Appeal Decision

Appeal Ref: APP/T2350/W/22/3304318

Pimlico House Gisburn Road Gisburn Clitheroe, Lancashire BB7 4ES

- The appeal is made under section 78 of the Town and Country Planning Act 1990 against a refusal to grant planning permission.
 - The appeal is made by Anne Walsh against the decision of Ribble Valley Borough Council.
 - The application Ref 3/2022/0144, dated 8 February 2022, was refused by notice dated 21 March 2022.
 - The development proposed is the erection of a random stone dwelling.
-

Proposed Plans & Elevations
 Land to the rear of Pimlico Barn
 Mill Lane
 Gisburn
 Lancashire
 Scale 1:100 & 1:50 at A1

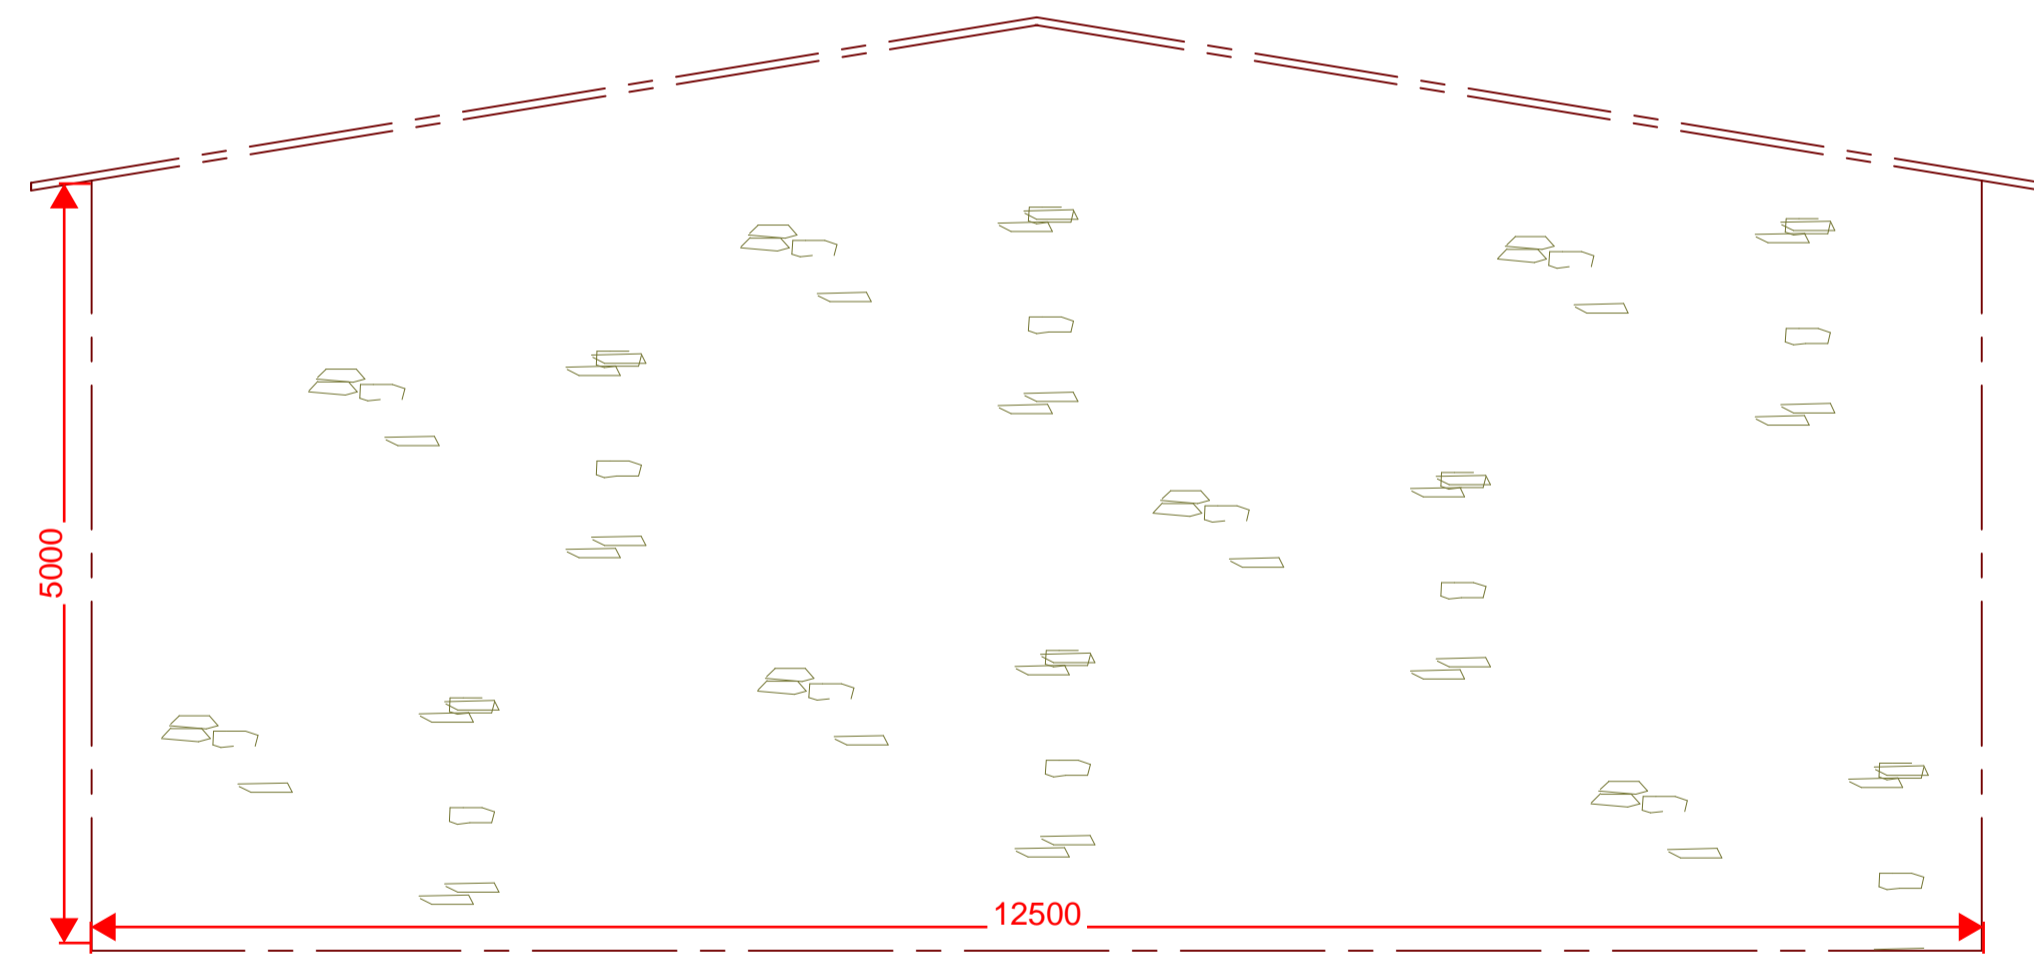
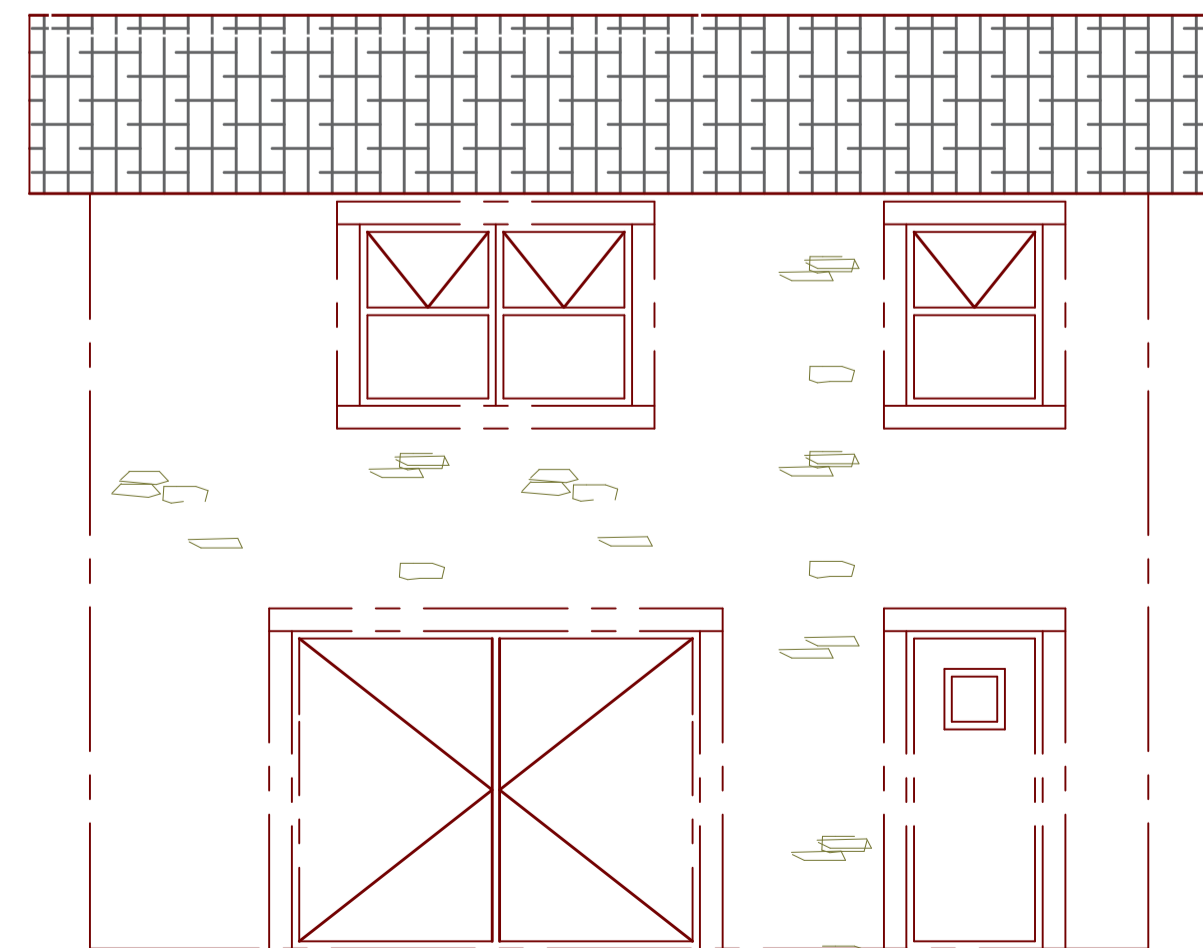
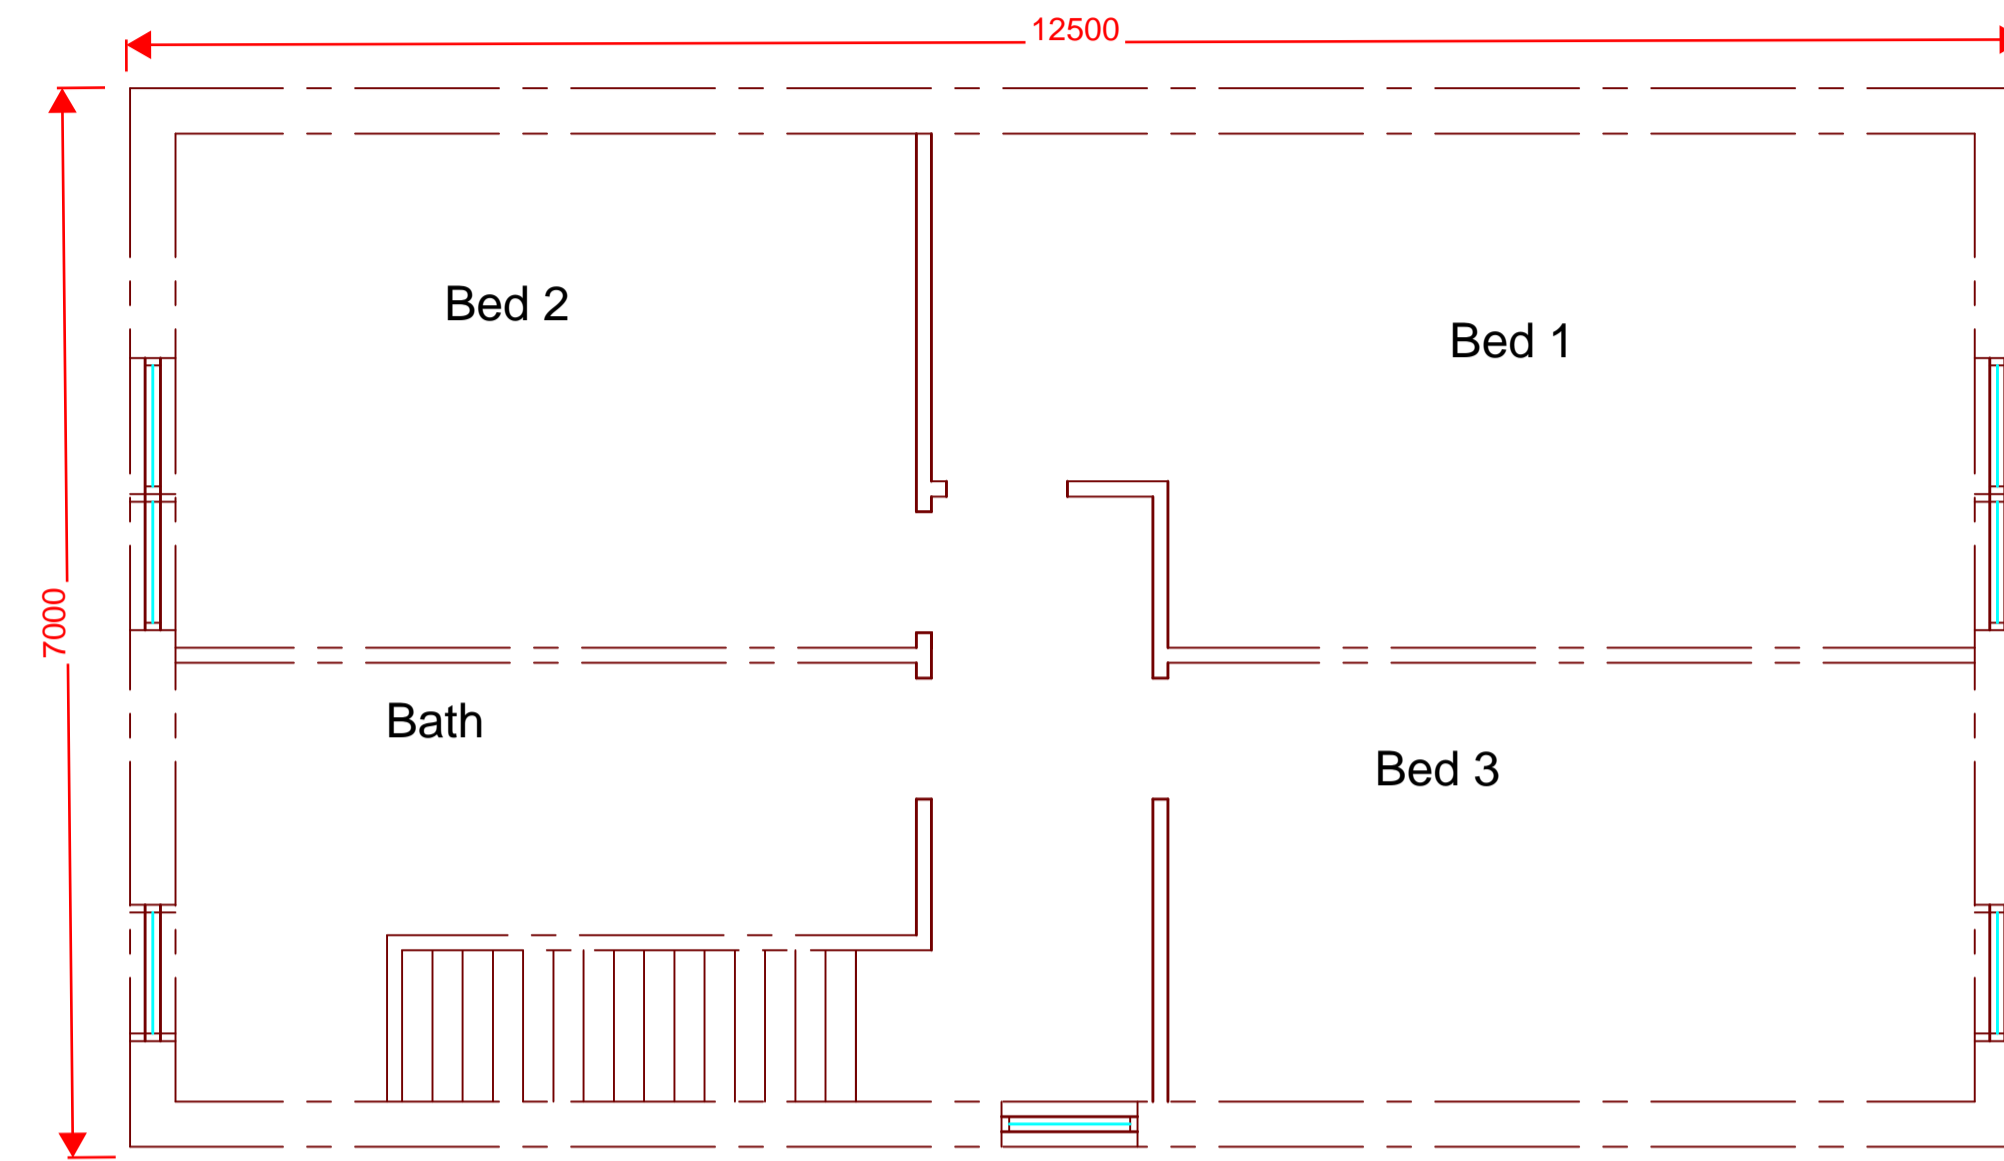
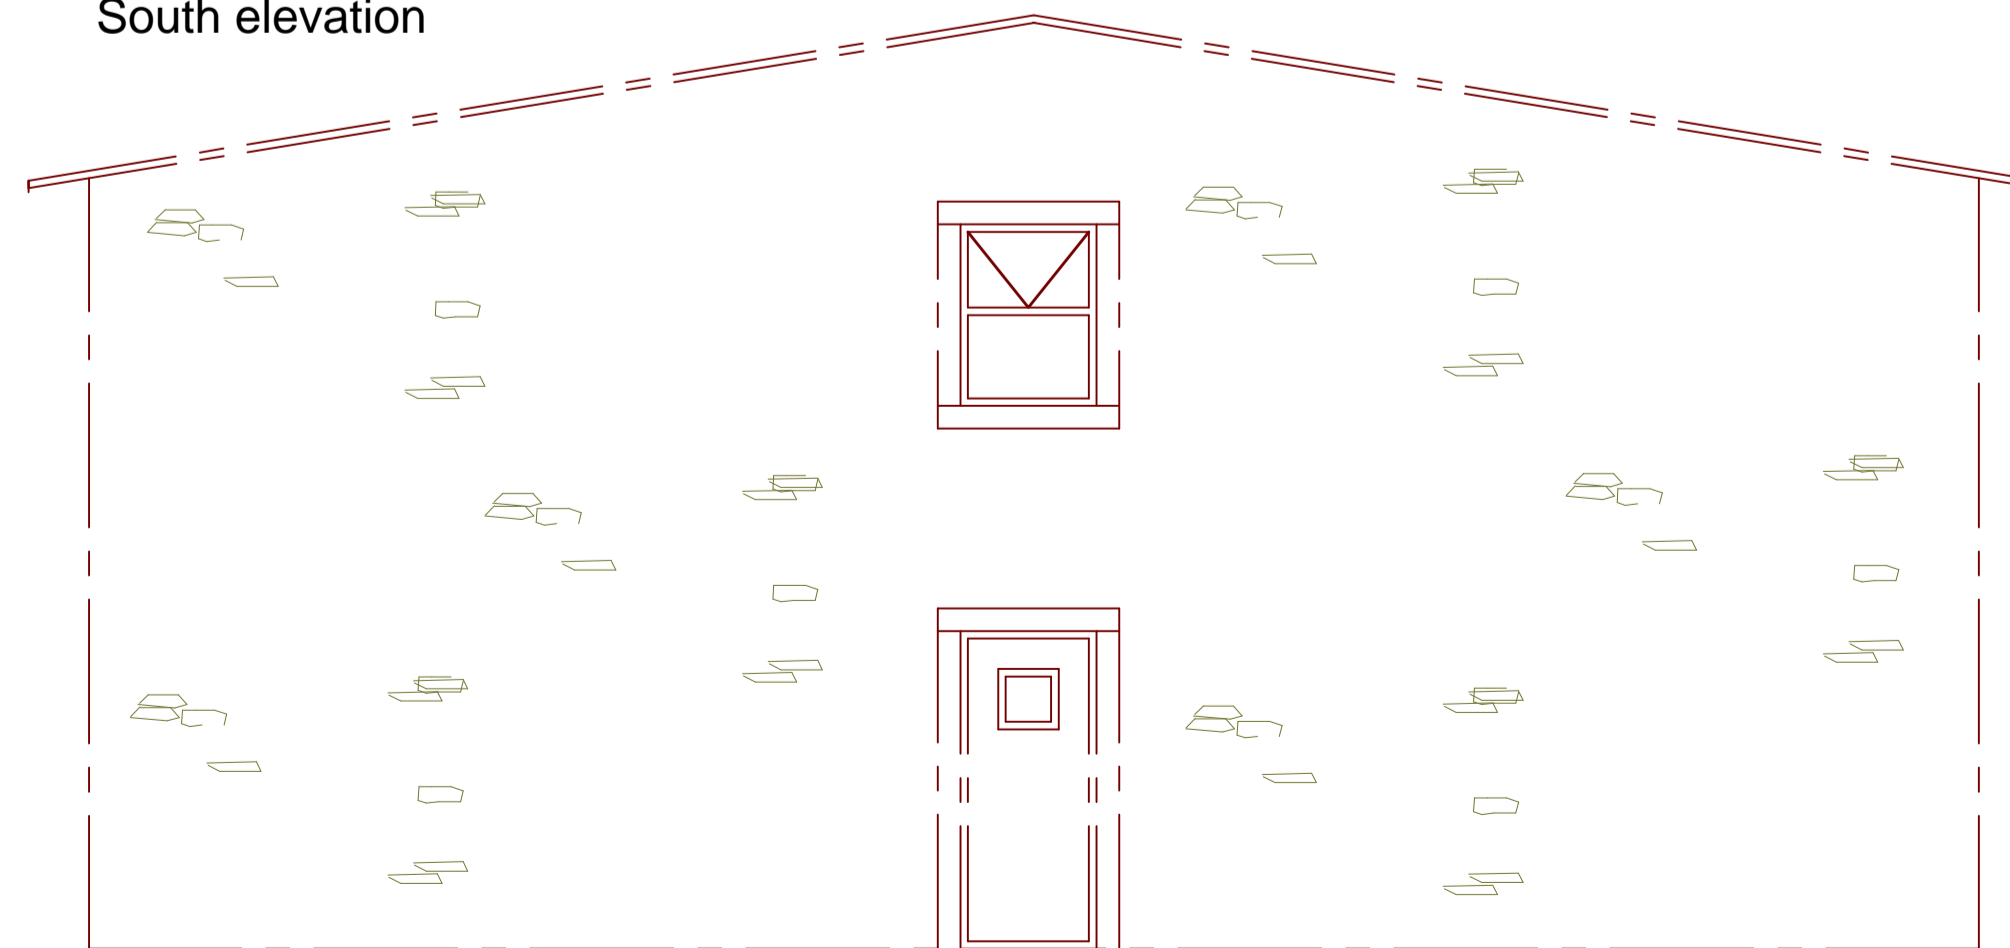
5. Whilst there is a varied mix of buildings and roofscapes in the area, these maintain a traditional and cohesive appearance in terms of proportions and roof pitch. In contrast the appeal proposal would have a relatively wide frontage compared to the adjacent residential buildings, and its depth would also be longer. Although it would have a similar height to surrounding buildings the additional depth would result in an anomalously wide gable and shallow roof pitch. Notwithstanding the intention for the gable and roof pitch to mirror nearby properties, their appearance would not reflect those steeper traditional gables in the area, and the proposed dwelling would appear unusually wide and squat. In addition, the drawings, which are scaled, show the roof would also have large overhanging eaves to the sides. These would be an alien feature for a residential property in comparison to the surrounding built context against which the proposed building would be seen. In addition, the proposal would be highly visible in the area from Main Street and Mill Lane, and the appearance of the gable which would be most prominent in views could not be mitigated.

6. Whilst I acknowledge some of the features on the proposed dwelling reflect the dwellings on Stable Close, such as the fenestration, the overall composition of all the elements which make up the external appearance of the proposal, such as the width and position of the windows, would not result in a locally distinctive or cohesive design. Although suitable materials can be conditioned this would not overcome the overall proportions and expansive gable. The fact the site is not within the CA or Area of Outstanding Natural Beauty does not lessen the harmful effect the proposal would have on the character and appearance of the area.
